Consultation Response from KC, Trees
2024/91008 adj, 115, Westfield Lane, Wyke, BD12 9LY
Variation condition 1 (plans) on previous permission 2023/90909 for reserved matters application pursuant to outline permission 2020/90436 for demolition of 1 dwelling and erection of residential development and associated works with details for access
Date Responded: 18/06/2024 Responding Officer: Jack Dunn Responding Ref: 10a/06

Westfield Lane, Wyke
SITE PLAN AND LOCATION PLAN

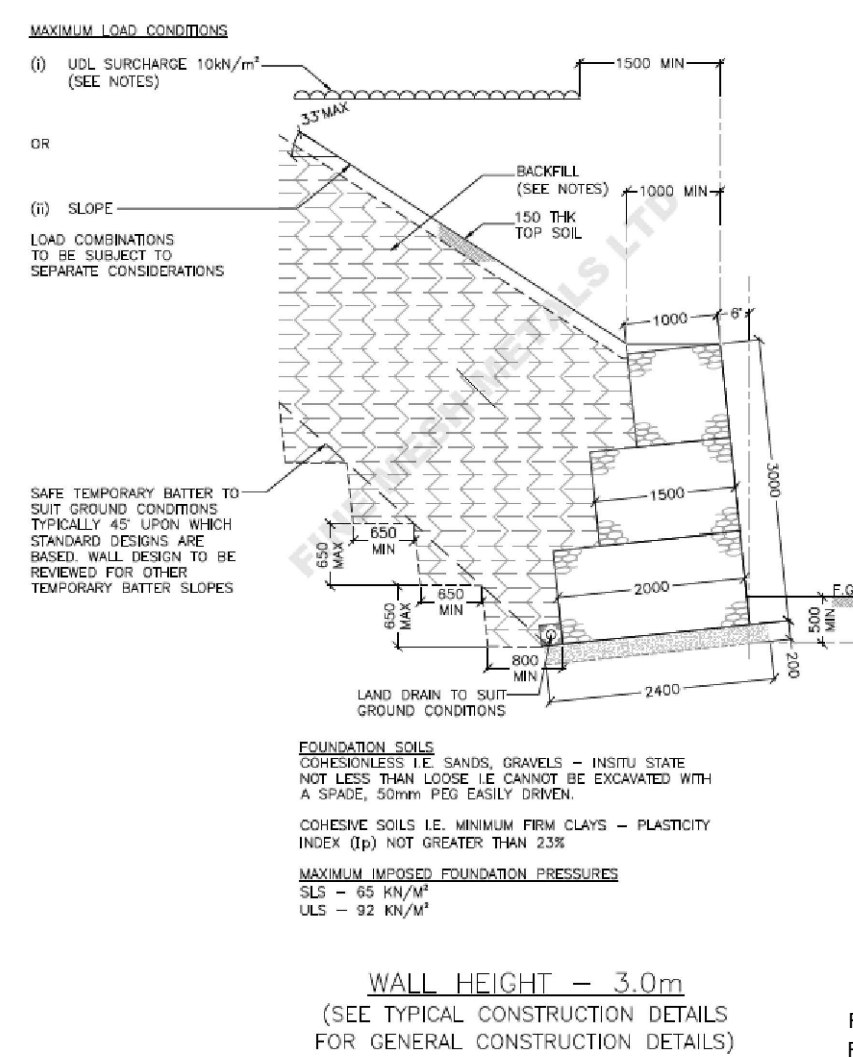
The tree information between the Landscape master plan R/2679/1E and Tree protection plan don't appear to add up. Tree T1 doesn't seem to show on the tree protection plan whereas it does on the landscape masterplan. This is a protected Tree and would require replacement planting if it has already been removed. There is currently replacement planting for G1.1, G1.2 and G1.3 which is sufficient however the replacement planting showing on the Landscape master plan needs to include a replacement for T1 and also T2 which had previously been down for removal. Other than this there is no further comments with regard to the rest of the site.

There is a holding objection until the tree information is consistent across all plans.
